From: [Mau, Russell E \(DOH\)](#)
To: [Zach Torrance-Smith](#)
Cc: [Melissa Schumaier](#)
Subject: Re: AU-26-00007 Hill - Notice of Application
Date: Monday, May 18, 2026 3:41:27 PM

The Department of Health (DOH) Office of Drinking Water (ODW) has reviewed the application generating the following official comments:

CDS is requesting comments on the following Accessory Dwelling Unit application: AU-26-00007 Hill.

PUMP HOUSE

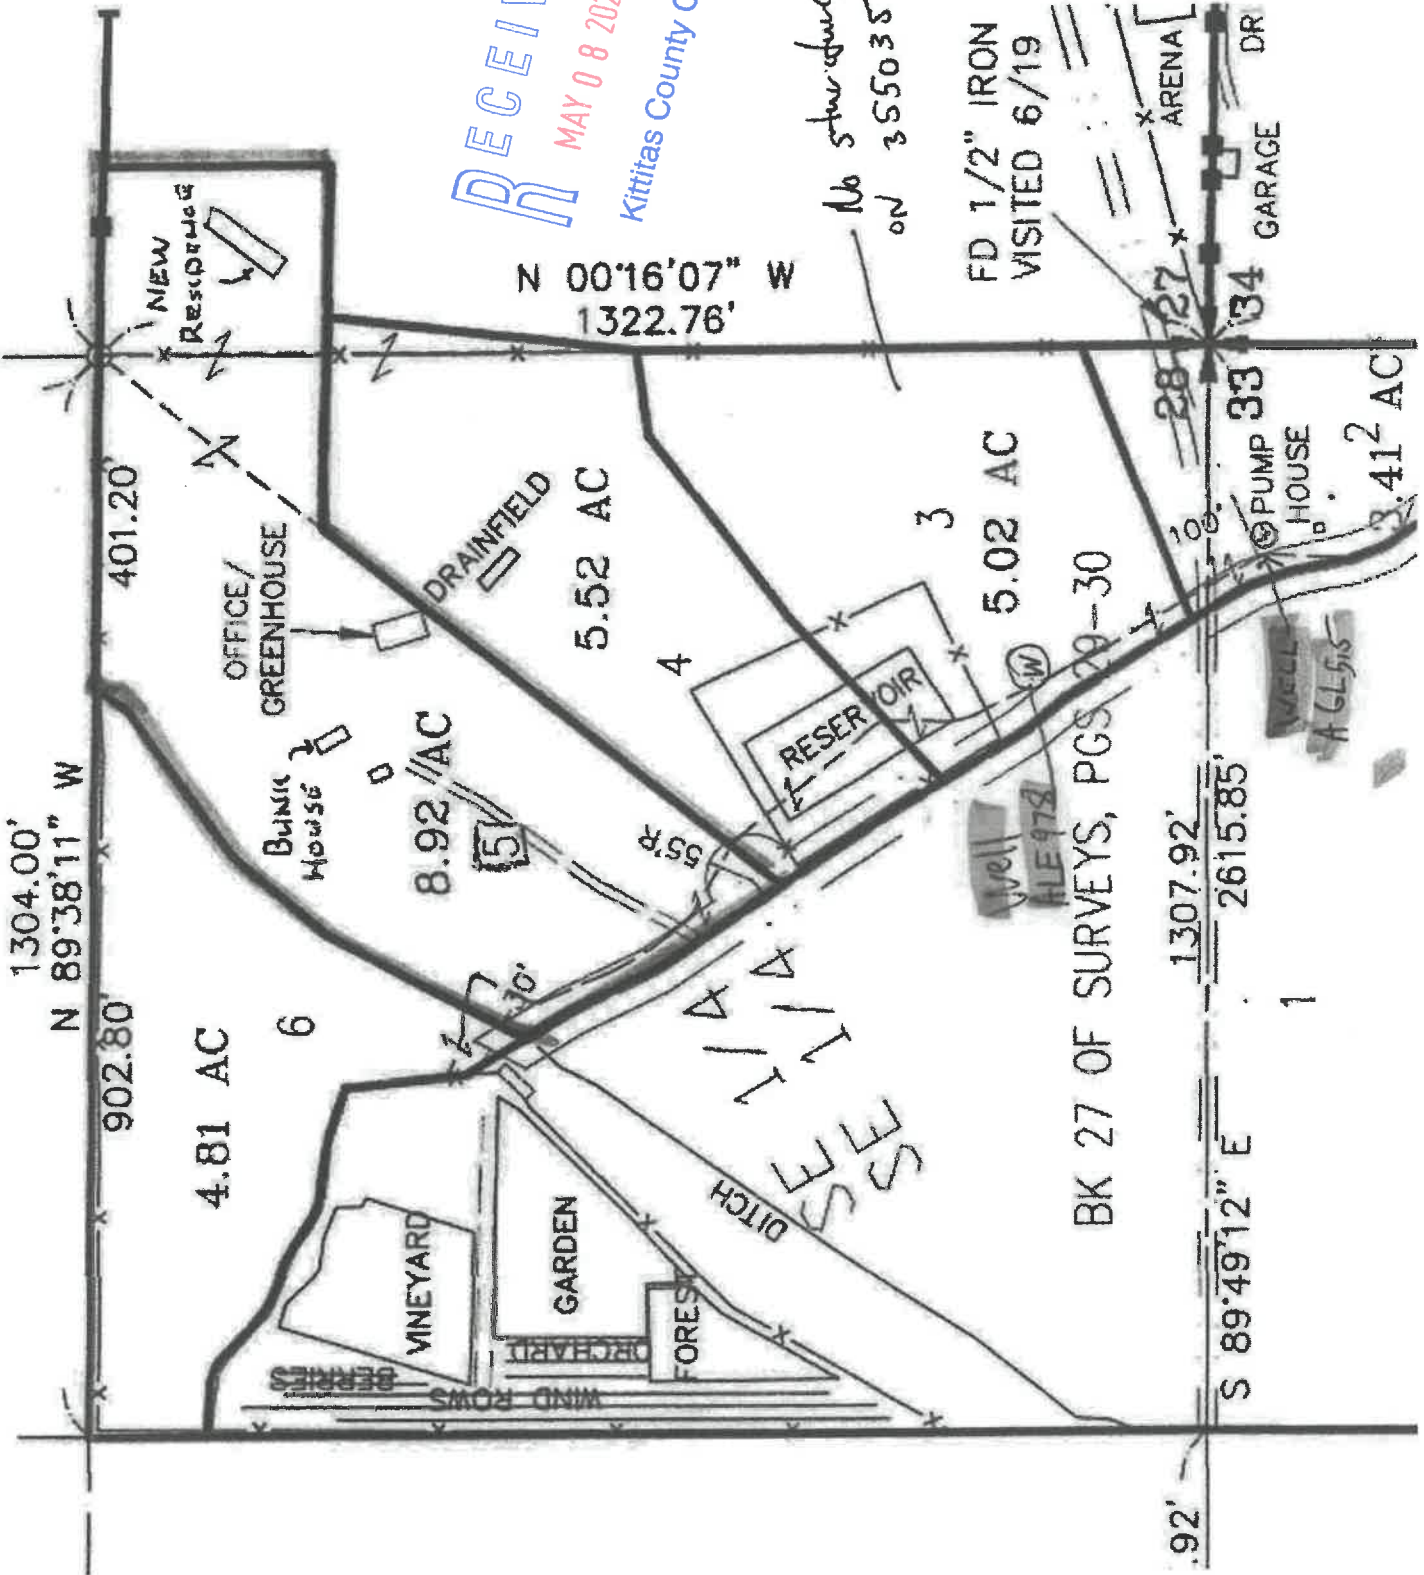
- Two single-family dwelling units served by the same well does not meet the definition of a public water system.
- If the occupancy of the two single-family dwelling units changes, then that occupancy needs to be evaluated to see if it meets the definition of a public water system.
- If a third dwelling unit is connected to this same well, then that meets the definition of a Group B public water system.
